From: [Dixon, Julia](#)
To: [A38 Derby Junctions](#)
Subject: A38 Derby Junctions - Deadline 7 - Comments of Network Rail Infrastructure Limited to Deadline 6 submissions [ADDGDD-LIVE.FID3076379]
Date: 10 March 2020 10:35:37
Attachments: [image006.png](#)

Deadline 7 – Submission of Network Rail Infrastructure Limited in response to certain of the Applicant's Deadline 6 Submissions

(A) Ford Lane Bridge

Drawing Number HE514503	Originator -ACM	Volume -DCO	Rev C02
Location A38_SW_PR_ZZ		I Type I Role I Number -DR-DC-9908

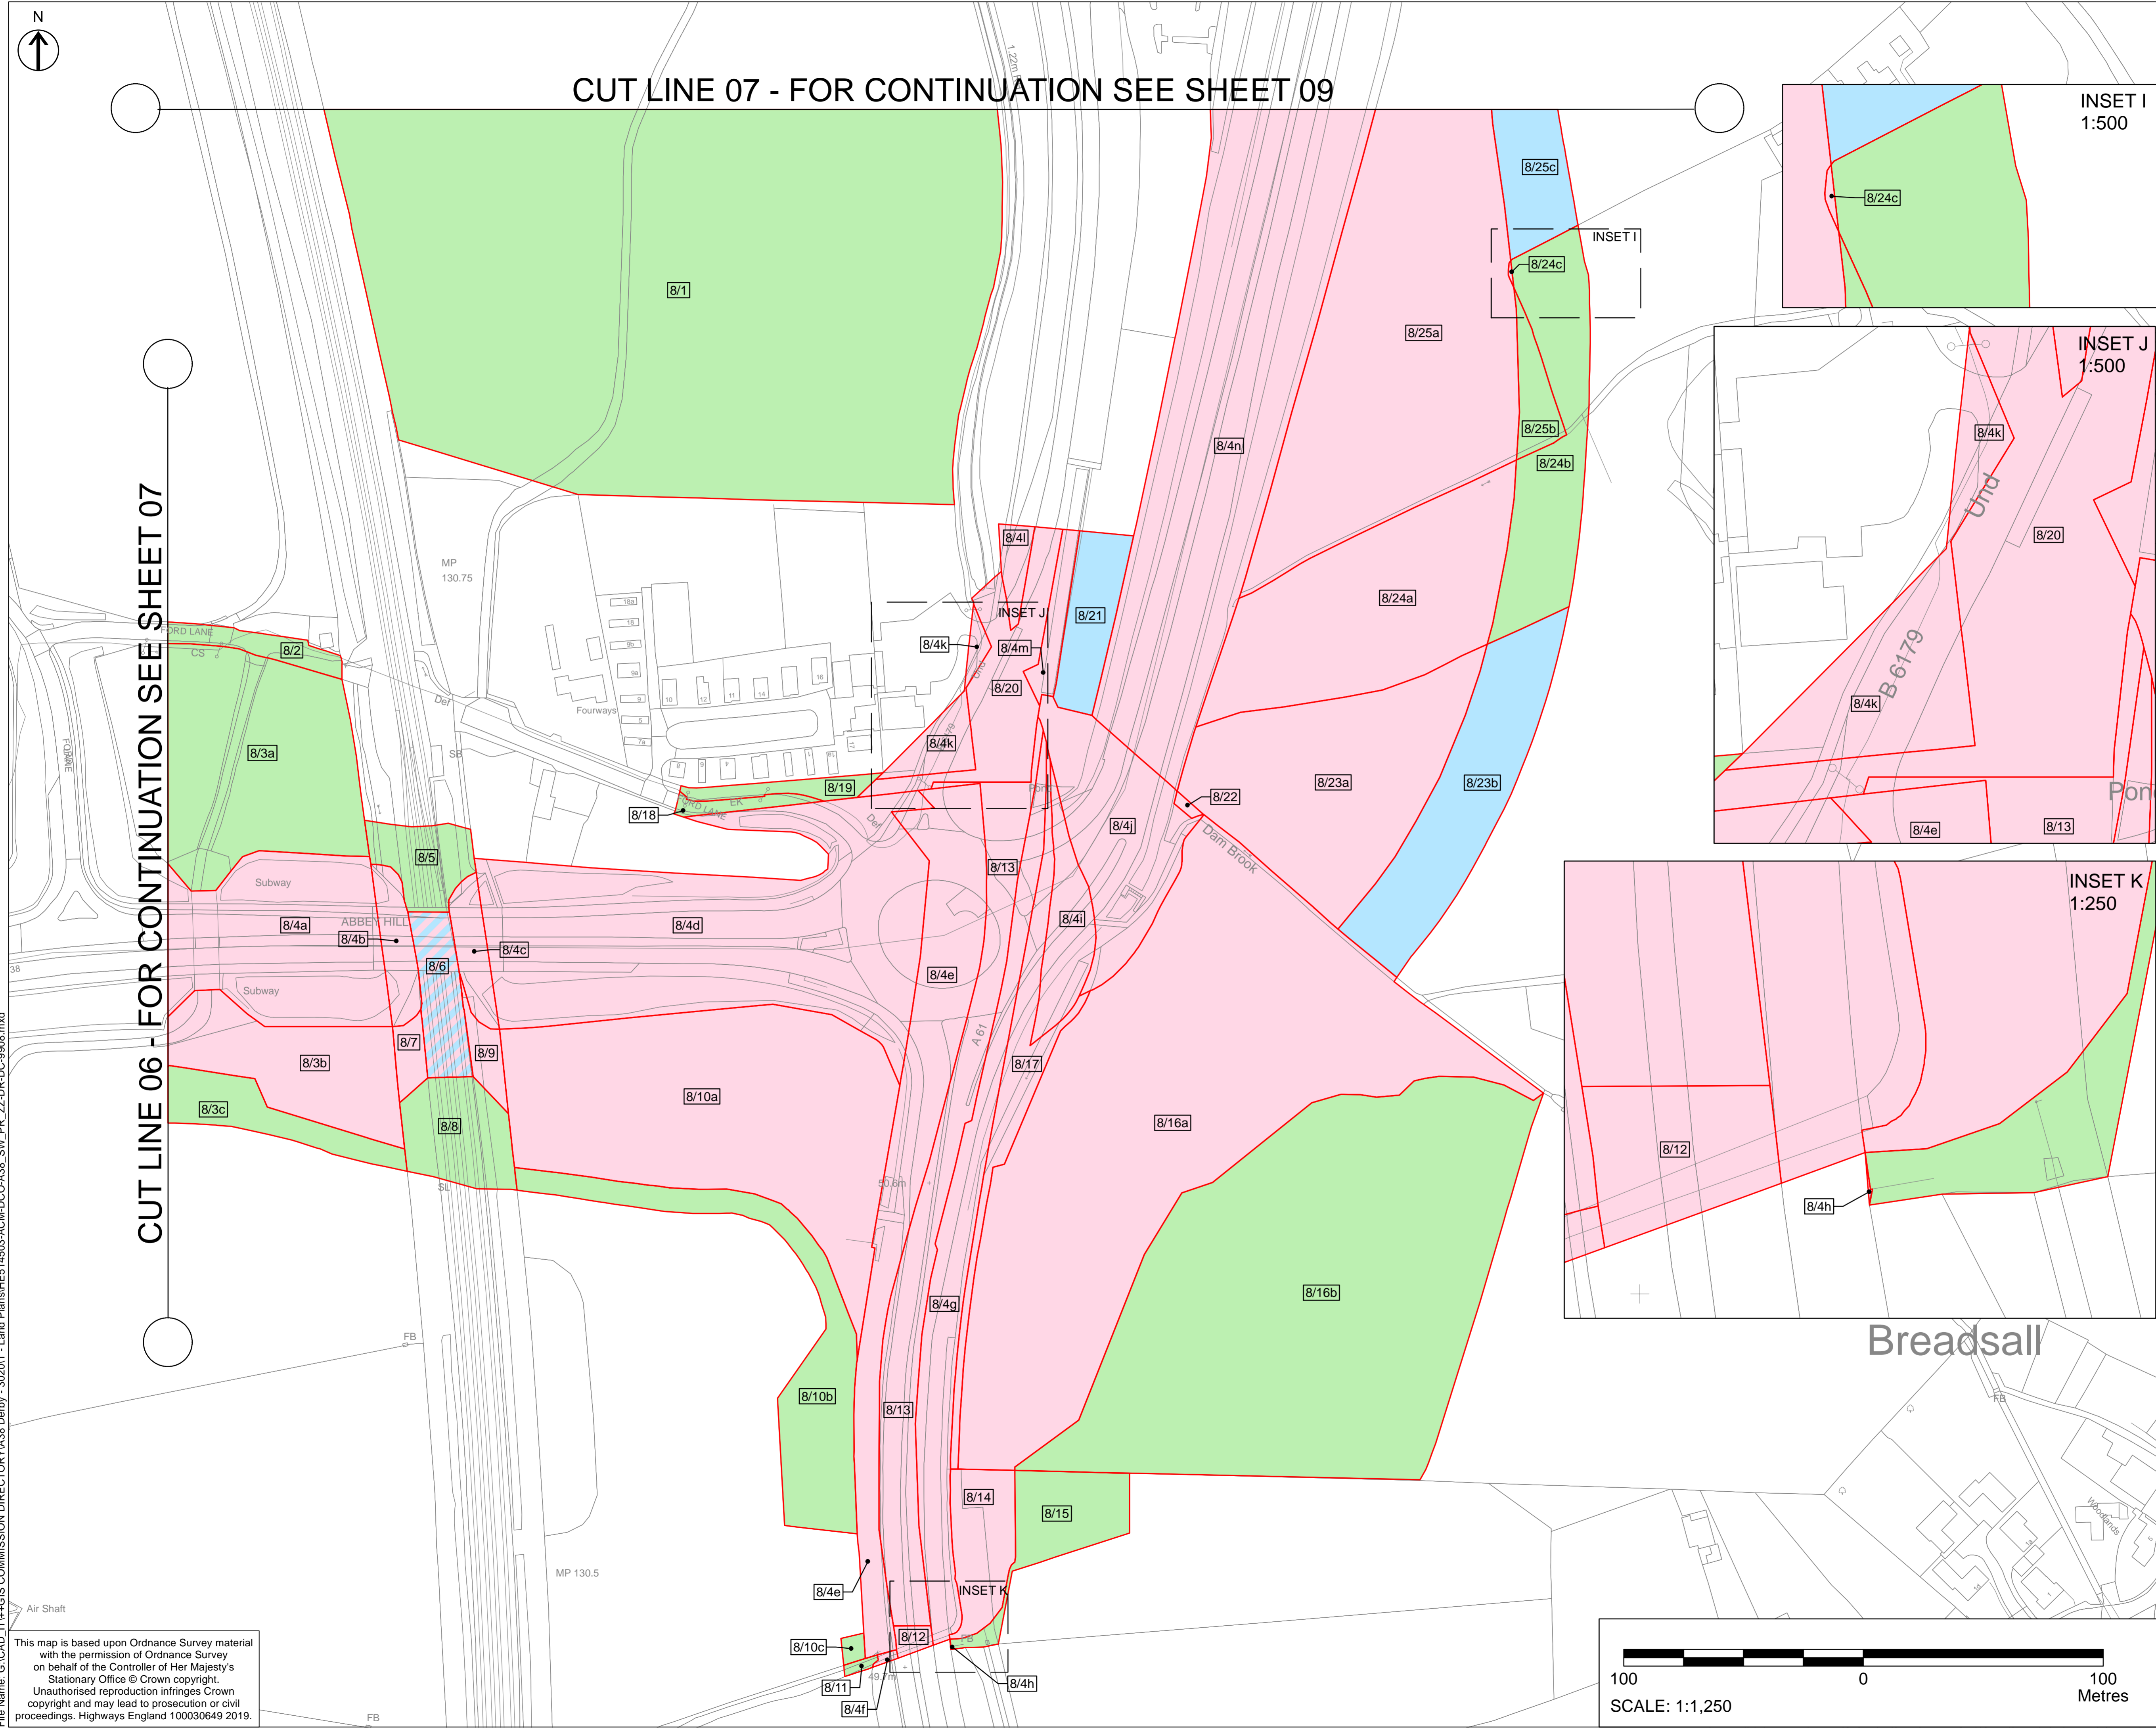
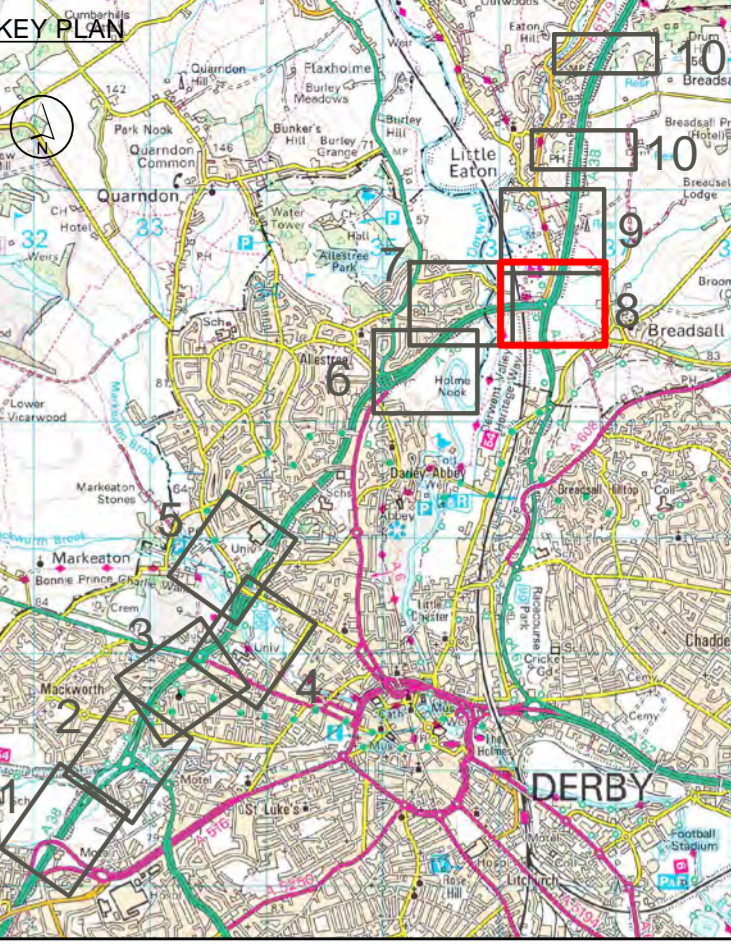
Network Rail's Deadline 7 submission: It is believed that there is a typographic error in the above response by HE in that Plots 8/5 "and" rather than "to" 8/8 are required temporarily. Plot reference

numbers 8/5 and 8/8 are referred to in Schedule 7 "Land of which temporary possession may be taken" in the draft DCO (REP6-002)
